Re: Application R/230/19/PL Springfield House, Springfield Road, Rustington

We are writing to object to the above application as follows:

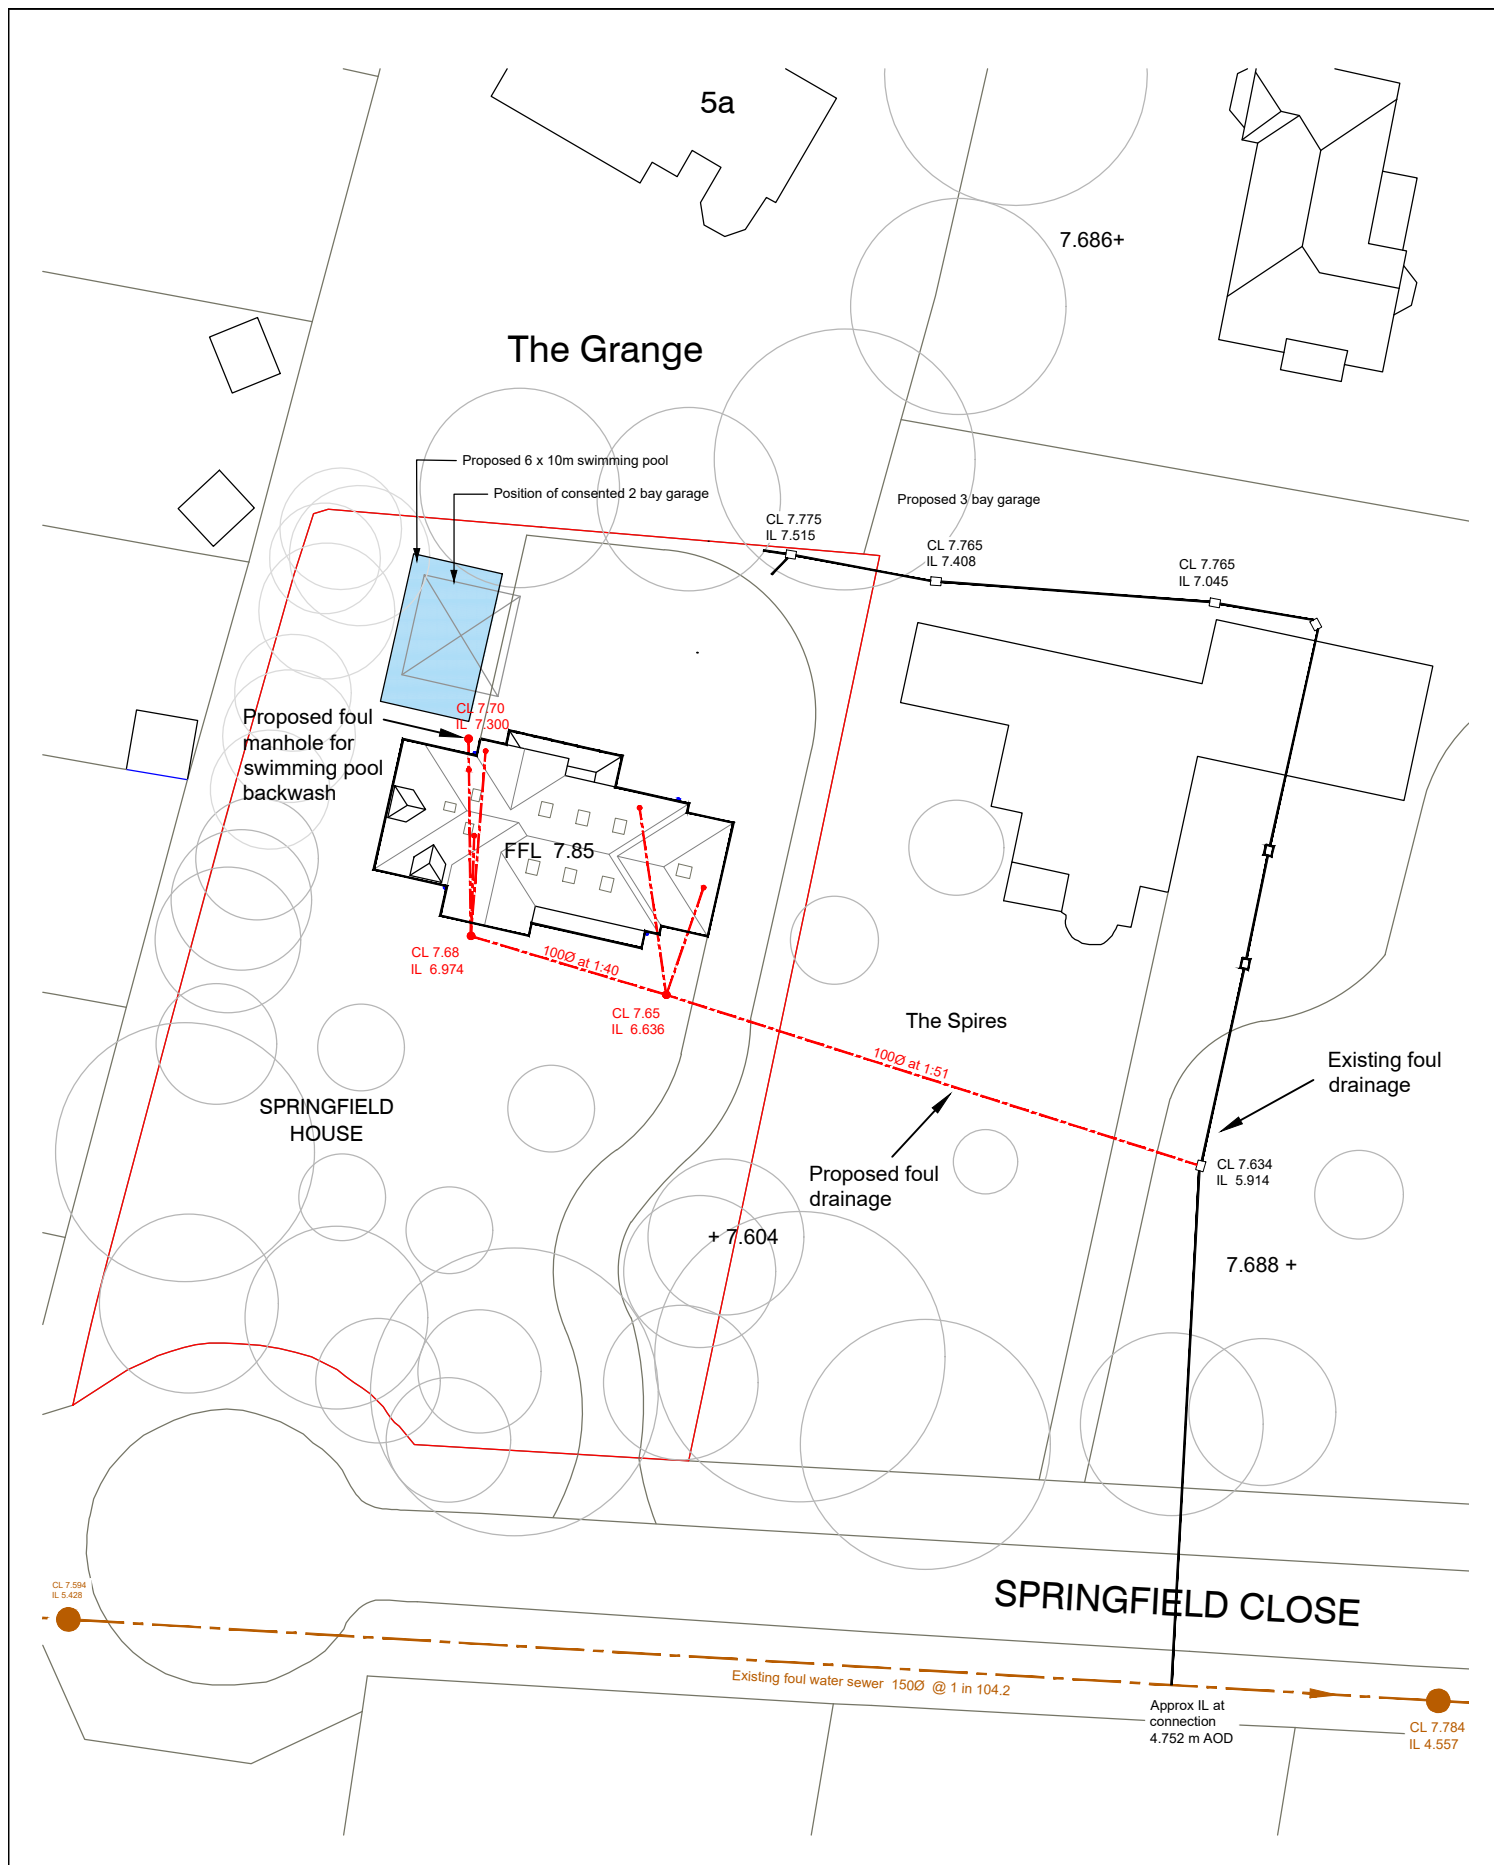
Swimming pool: The location of this pool is shown in different positions on the Surface water drainage layout and Location plans. The size needs clarification as it is shown as 6 x 10m on one plan and 6 x 12m on another.
